75-85 Harrington Street Mixed Use Mod 3 (SSD 7037 Mod 3)
Request for Additional Information

Additional comment from Roads and Maritime Services within Transport for New South Wales

Sheet No.....4..... of.....18.....

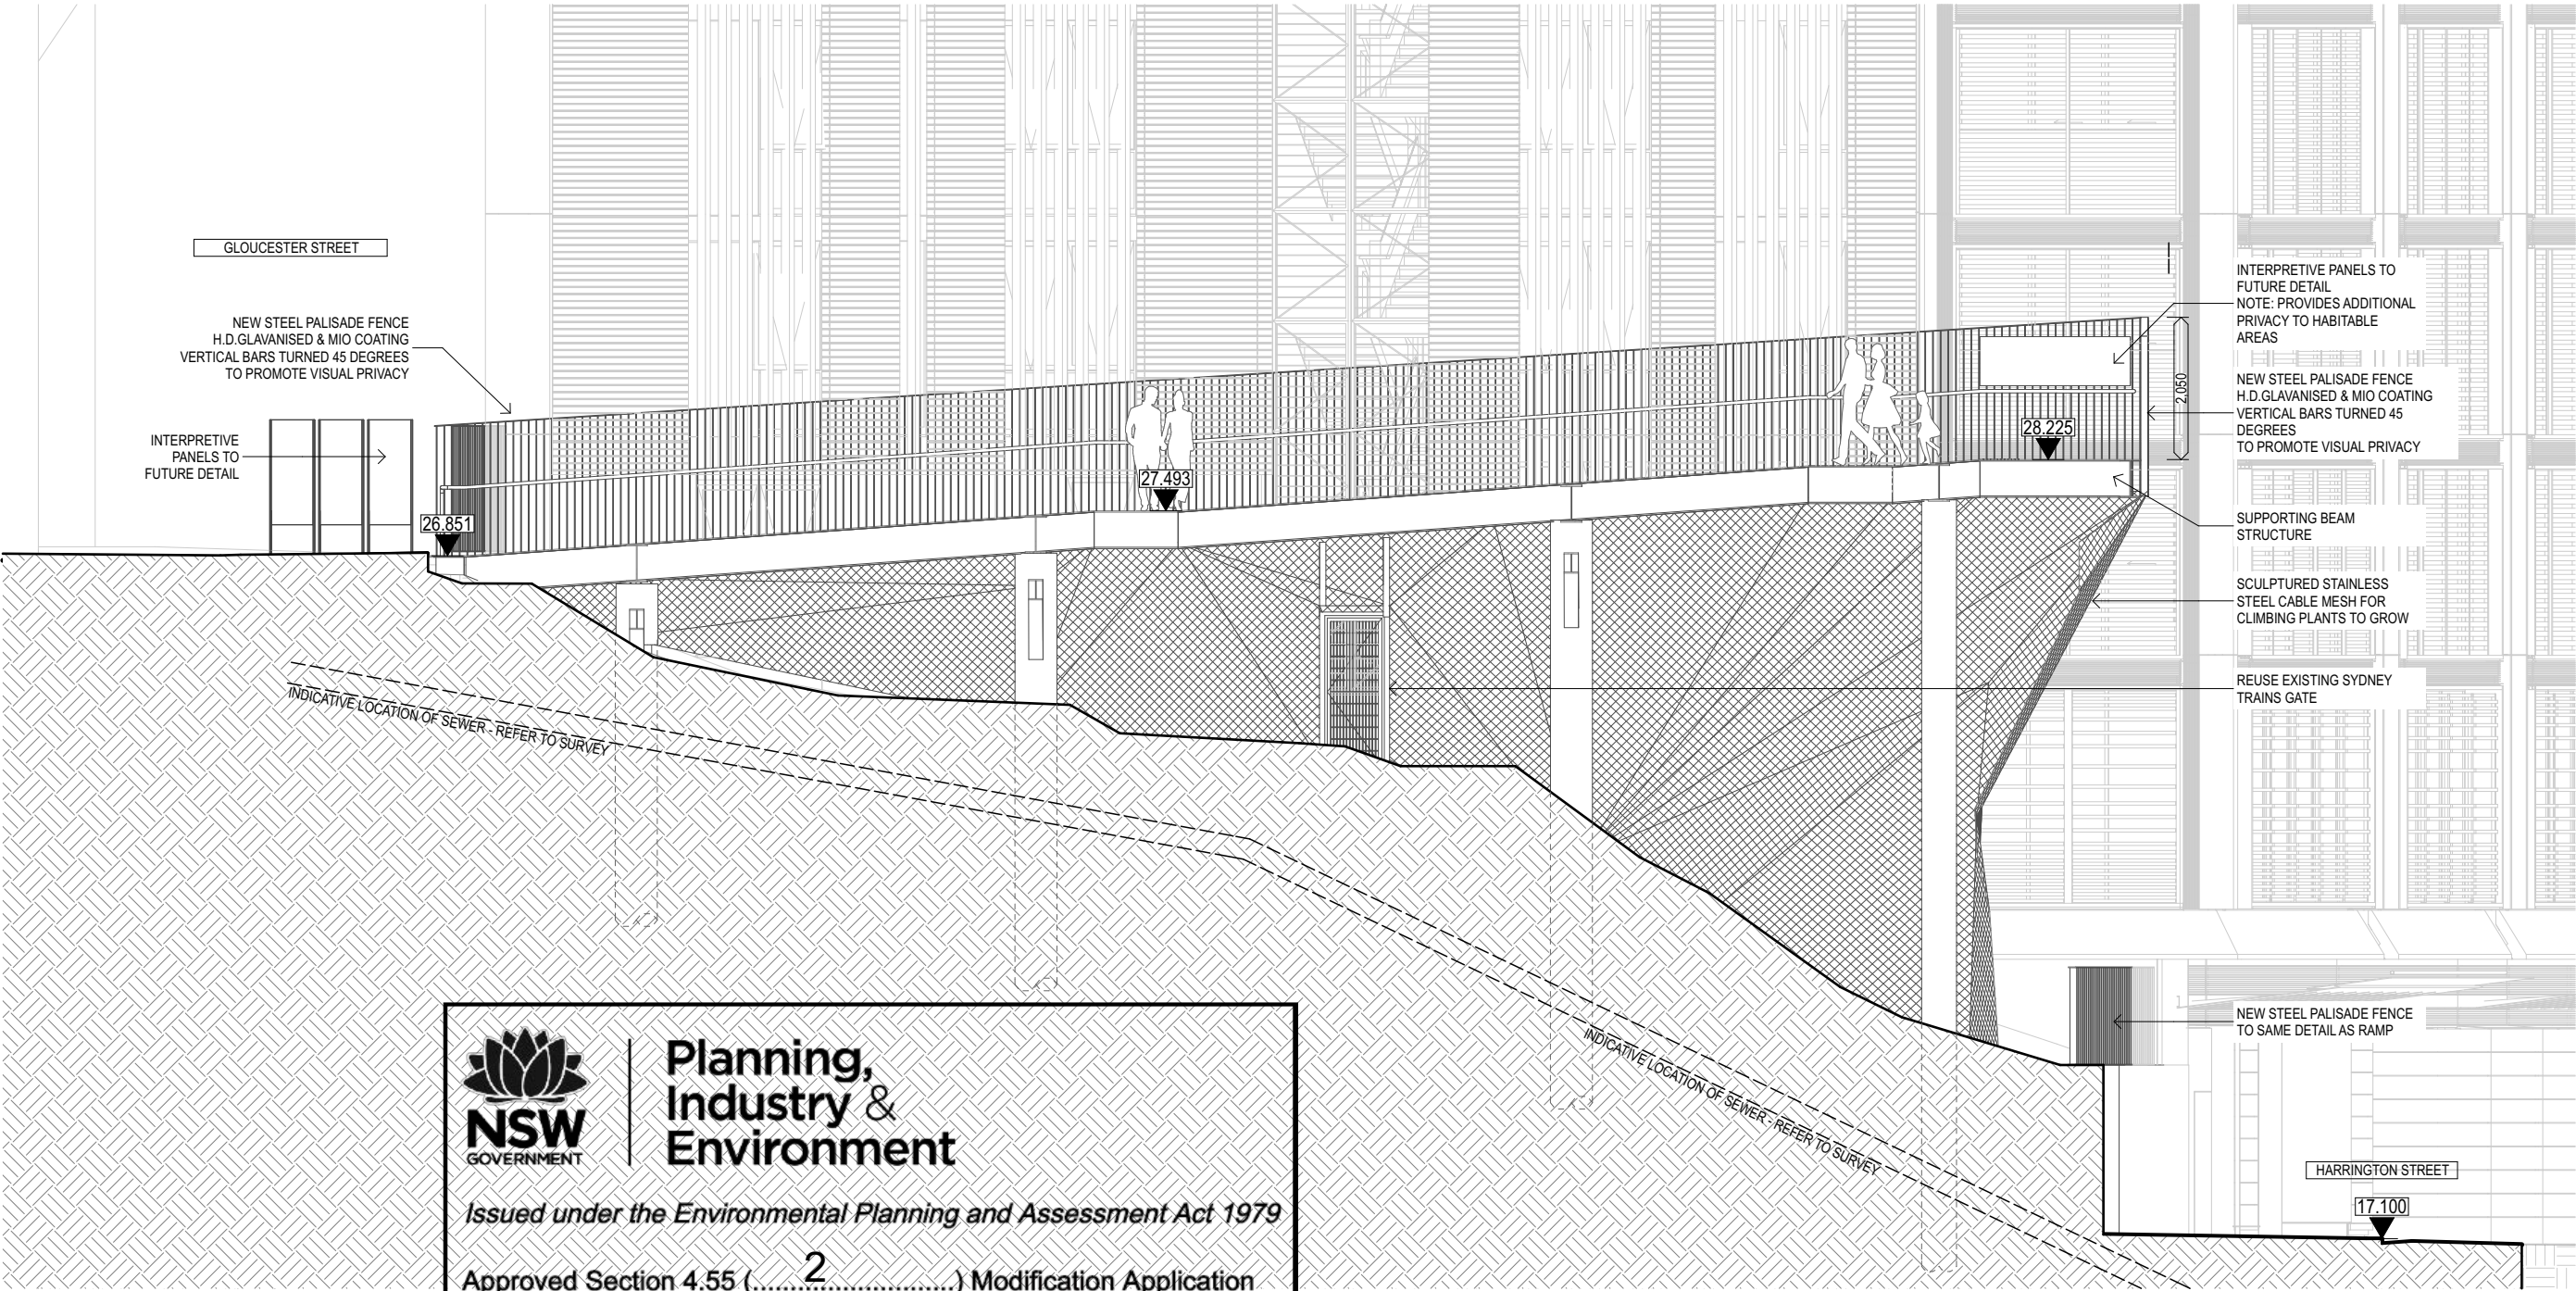
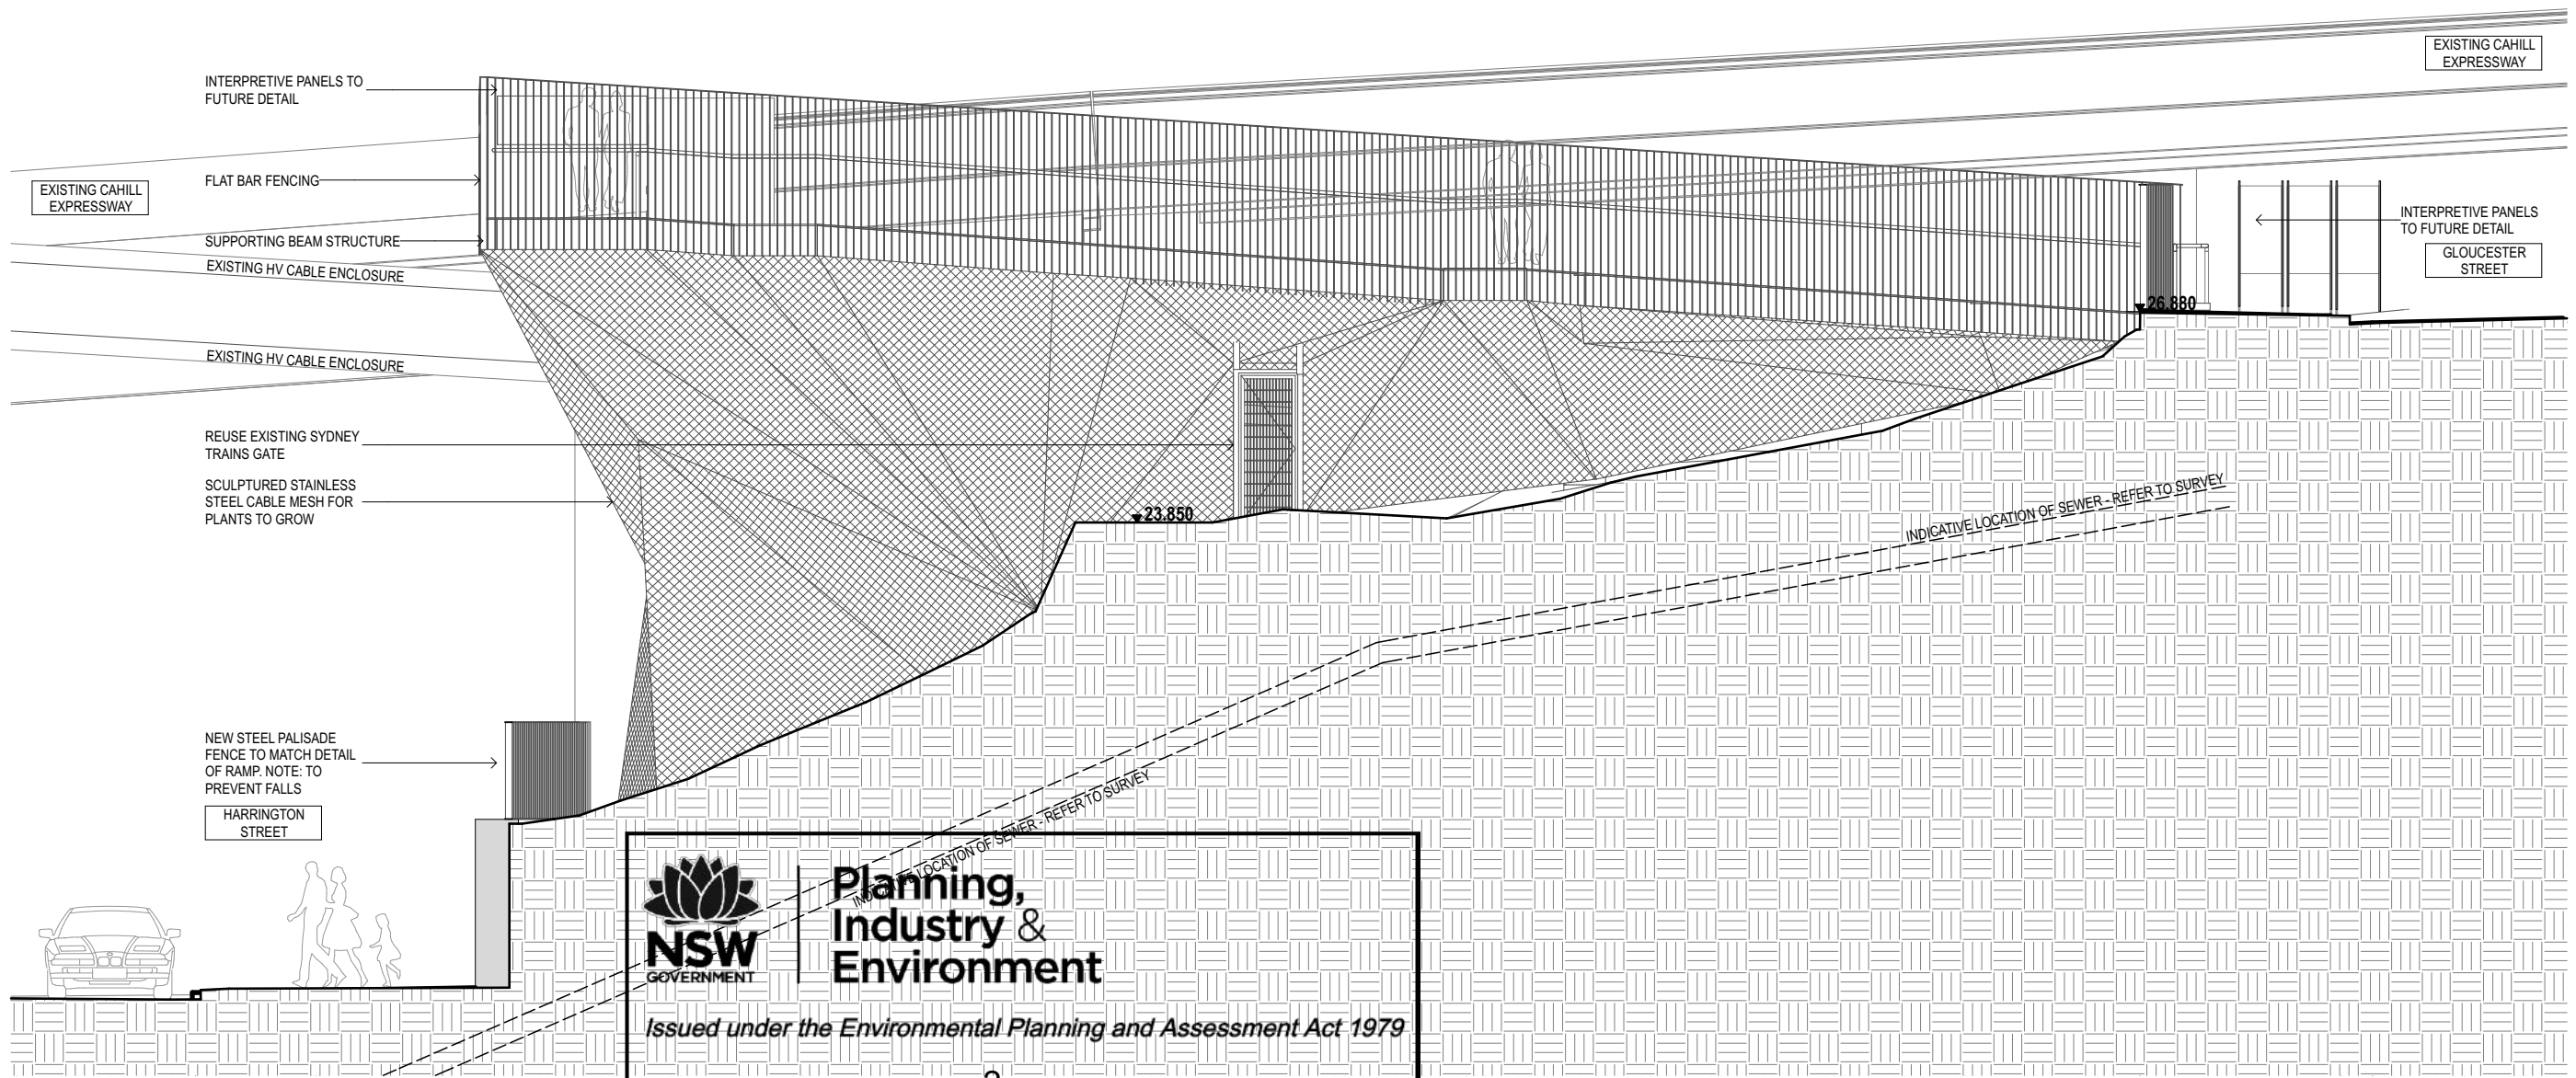
TfNSW has re-reviewed the related information relating to the shared use of the proposed ramp for both pedestrian and cycling.

Ultimately, TfNSW has no objections for the proposed shared use of the ramp. However TfNSW does reiterate and support comments and recommendations from the Access Report prepared by Morris Goding Access Consulting. Whilst the minimum shared path width of 2.5m as per Austroads is being met, it may not be wide enough to cope with pedestrian volumes that are likely to use the ramp and as such should include design measures to reduce any potential conflict between cyclists and pedestrians.
